Figure 2 - Extraction Stages

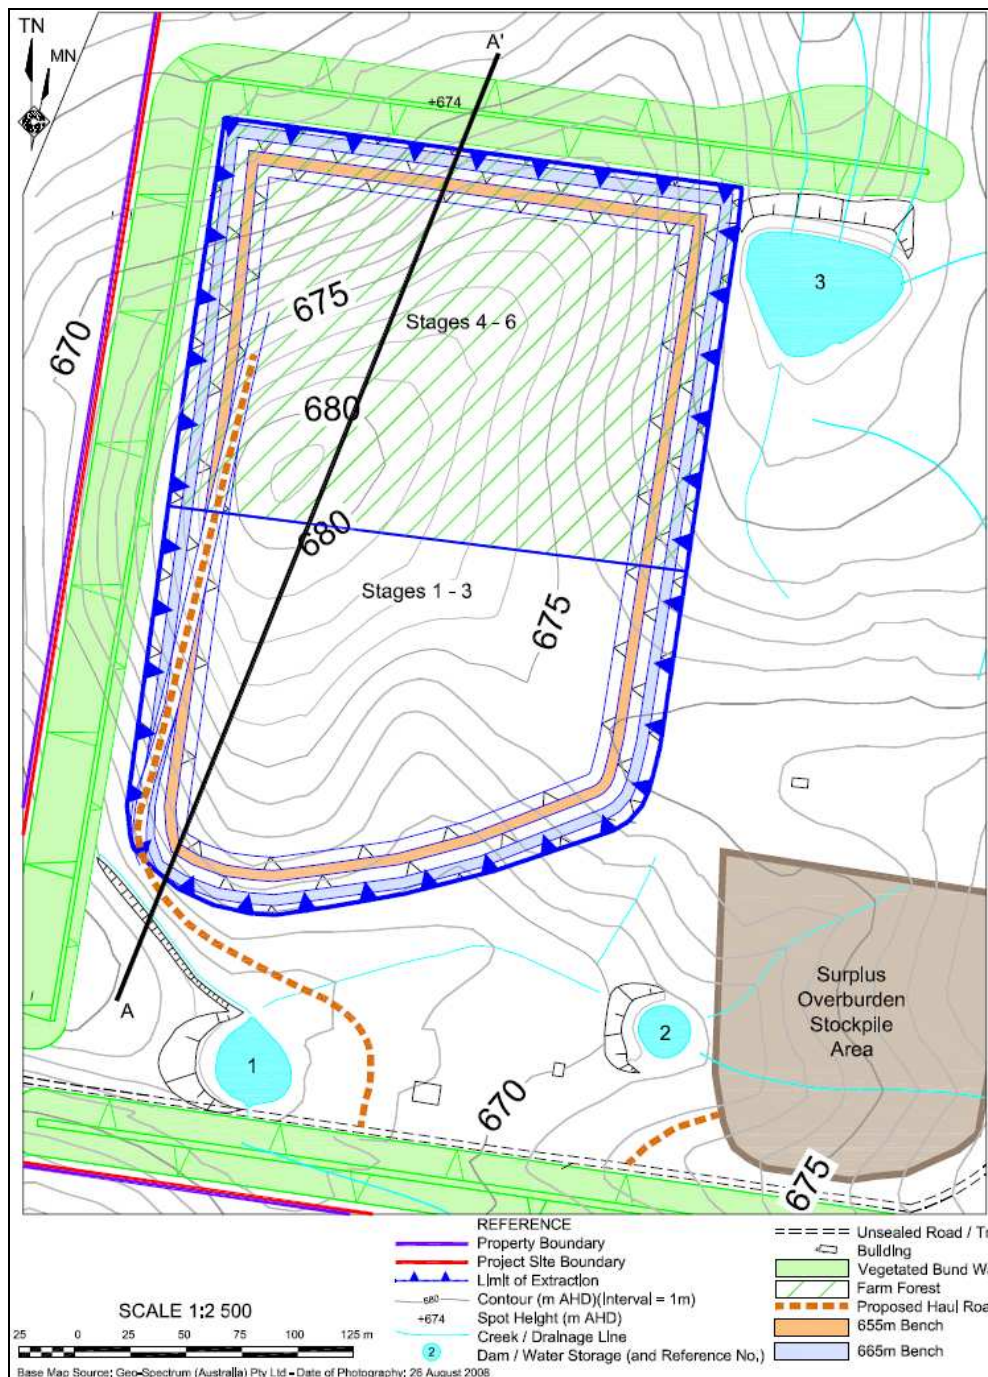
5. Please explain how excavation works will be progressed (i.e. will the excavation area for stages 1-3 followed by area for stages 4-6 be open all at once or is it likely to be opened in cells).

7. Please confirm the maximum depth of excavation. Figures 2.4 and 5.7 of the EA show excavation of up to 645m AHD, whereas section 5.12.3 of the EA states excavation of up to 630m AHD.

The method of extraction is outlined in Section 2.5.2 of the EA. Essentially, extraction would involve the extraction of the full area of Stage 1 to a depth of 665m AHD over a period of approximately 8 years. When extracting the shale, emphasis would be placed upon balancing the removal of the overburden materials and the underlying fresh shale. Therefore, it would take a few years to remove the overburden from the Stage 1 area. Once all overburden is removed from the Stage 1 area and only shale is present, the extraction would involve the extraction to the levels nominated as 665m AHD (Base of Stage 1) 655m AHD (Base of Stage 2) and 645m AHD (Base of Stage 3).

Once extraction approaches the base of Stage 3, the Proponent would commence the overburden removal from Stage 4 to ensure sufficient fresh shale is exposed for extraction, prior to the removal of the last shale from the floor of Stage 3. The same process of progressing downwards in benches would occur, i.e. extraction to 665m AHD (Stage 4), 655m AHD (Stage 5) and 645m AHD (Stage 6).

The maximum extraction depth would be 645m AHD. The reference to 630m AHD is in error and relates to the maximum depth at which drilling defined the shale resource on the property. The proposed maximum depth of extraction would be 15m higher.

Figure 3 - Haul route

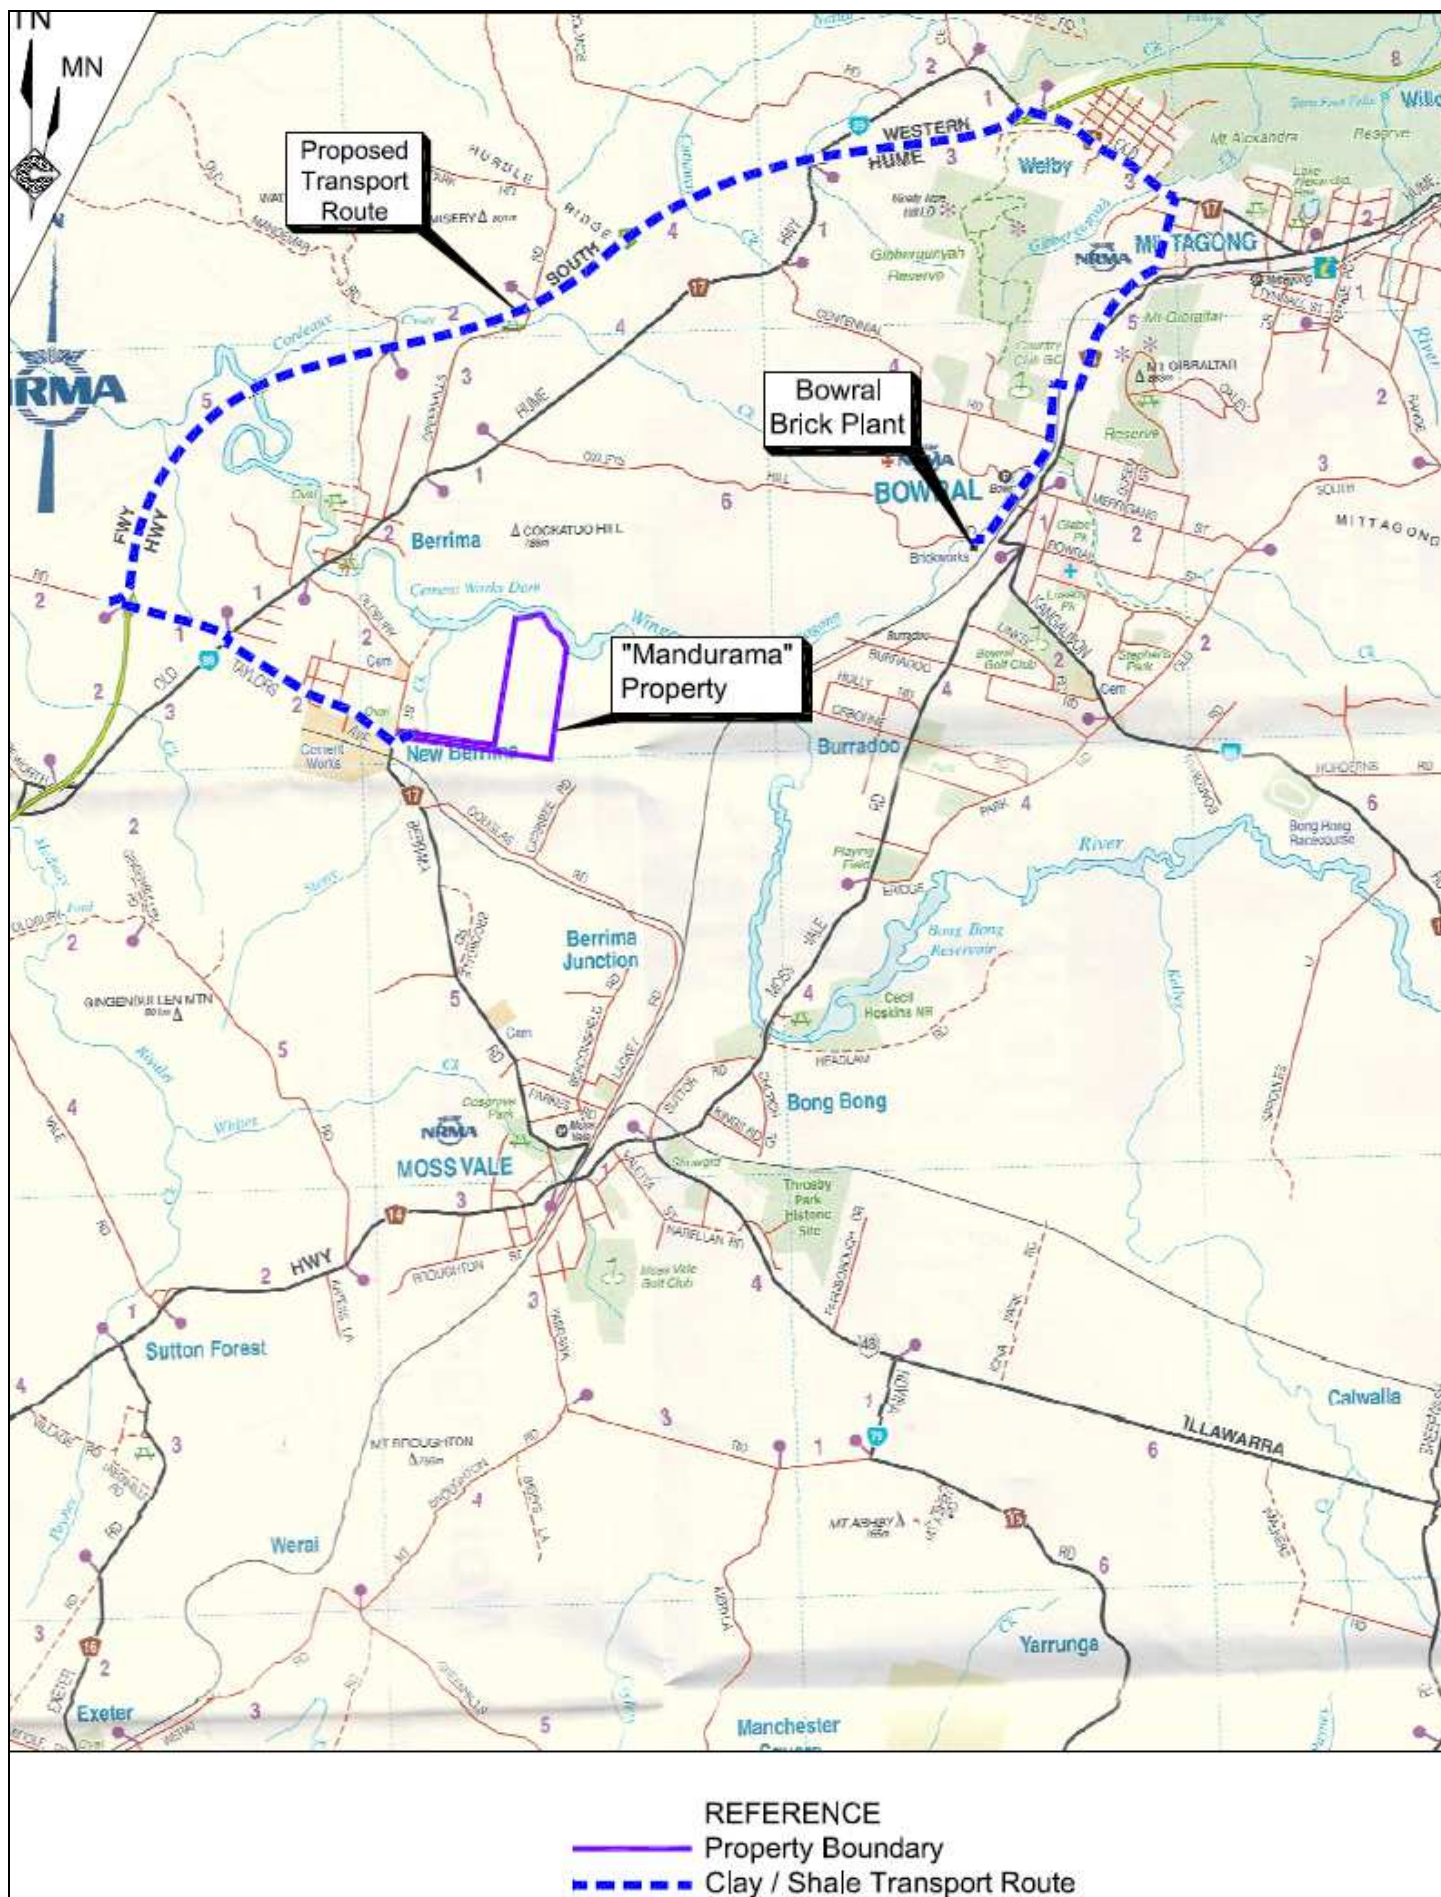
1. Please justify why the local roads (and corresponding intersections) namely, Cavendish Street, Old Bowral Road, Lyle Avenue, Kirkham Road, Oxley Hills Road and Kiama Street have not been modelled as part of the traffic impact assessment. Justification provided in the EA (sections 5.1.2.3 and 5.1.3.3) is inadequate. You may also wish to refer to Council's submission for further info.

12. Please provide the traffic noise impact assessment along the remainder of the local roads where there are nearby sensitive noise receivers. In particular, the traffic noise assessment needs to consider the following local roads: Cavendish Street, Old Bowral Road, Lyle Avenue, Kirkham Road, Oxley Hills Road and Kiama Street.

"The proposal is estimated to generate only 17 vehicle trips in the peak hours with only 13 of these being heavy vehicles utilising the haulage route. This is an average of 1 truck vehicle every 4min and 37s or 1 truck every 8min 34s approaching or departing (i.e. in either direction). The potential truck traffic generated by the proposal of 13 heavy vehicle trips per hour will not create traffic delays at any intersection in isolation. Therefore the modelling of these intersections was considered to be unnecessary."

Essentially, this response is based upon the professional judgement of an experienced traffic engineer who spent time at each intersection along the route during peak hour observing traffic movements through each intersection. When undertaking predictive assessments of any environmental issue, reliance needs to be placed upon the professional judgement of an experienced traffic engineer rather than modelling just for the sake of it.

"The noise assessment undertaken for the Project by Spectrum Acoustics calculated a traffic noise level of 51 dB(A), Leq(1hour) at a receiver 17m from the transport route (Taylor Avenue) on the southern edge of New Berrima. This level is 9 dB below the 60 dB(A) daytime criterion for receivers adjacent to a collector road. Aerial photographs were reviewed to determine the nearest receivers to the local roads referred to in this request. This review established:

- Cavendish street is in an industrial area with no apparent residences;
- nearest residence to Old Bowral Road is at 60m;
- nearest residence to Lyle Avenue is at approximately 20m;
- there are no residences along the haul route section of Kirkham Road; and
- a possible residence on the eastern side of Kiama Road is at 24m.

Since these residences are all greater than 17m form the transport route to be used, traffic noise levels from the project would not exceed the 51 dB(A),Leq(1hour) predicted at New Berrima. This level is below the daytime criterion of 55 dB(A) for receivers near a local road. The DECCW (now OEH) released the NSW Road Noise Policy (RNP) in March 2011 and replaces the ECRTN, which was the basis of the original traffic noise assessment. The traffic noise criteria in the RNP are the same as the ECRTN criteria for local roads, however, and the criteria for collector roads are essentially less stringent. Compliance with the ECRTN criteria for this project."

Figure 4 - Surrounding residences

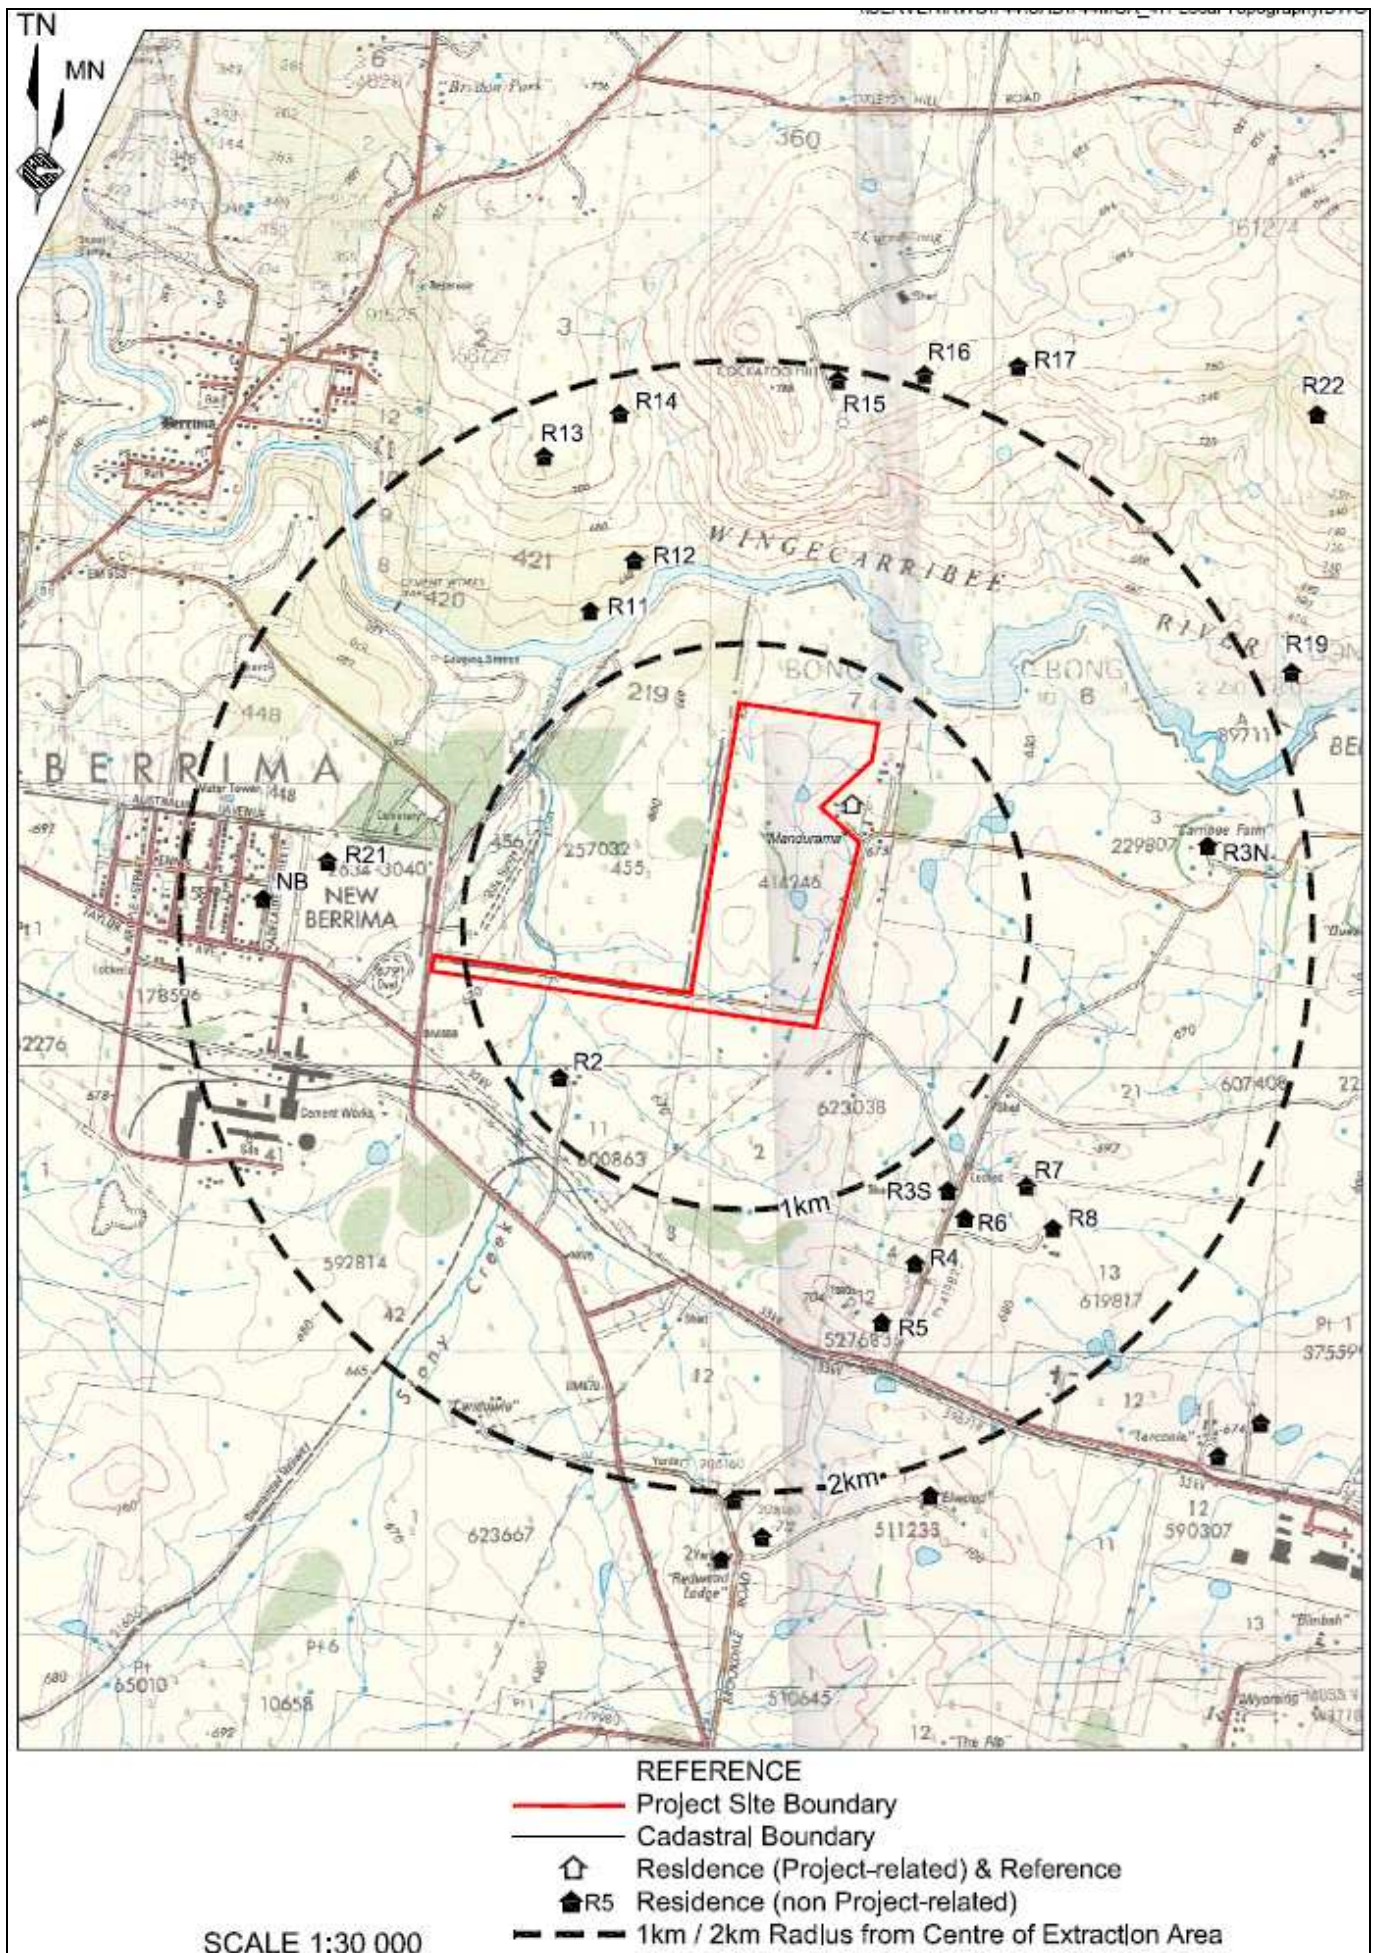
9. Section 5.3.6.5 of the EA states that the construction noise criteria will be exceeded by 4dB at one location with the implementation of mitigation measures. However, Section 5.1.1 of the noise specialist's report states that with the implementation of further measures the construction noise criteria may be exceeded by 2dB. Please clarify what is the exceedance, if any, of the construction criteria and if necessary propose further measures to ensure criteria is met.

The noise assessment (summarised in the EA) refers to the 4dB(A) exceedance at Residence 2 during the construction of the southwestern or southern bund wall. This was clearly under the worst case prevailing conditions of a northeasterly wind blowing towards the residence. A review of the recorded wind data for Moss Vale (EA Figure 4.3) reveals that winds from the northeast only occur for less than 15% of the year. Hence, it would be comparatively simple to achieve compliance at Residence 2 by committing to undertaking the construction of the southwestern or southern bund wall during periods when winds are <u>not</u> blowing from the northeast – a common operational practice.
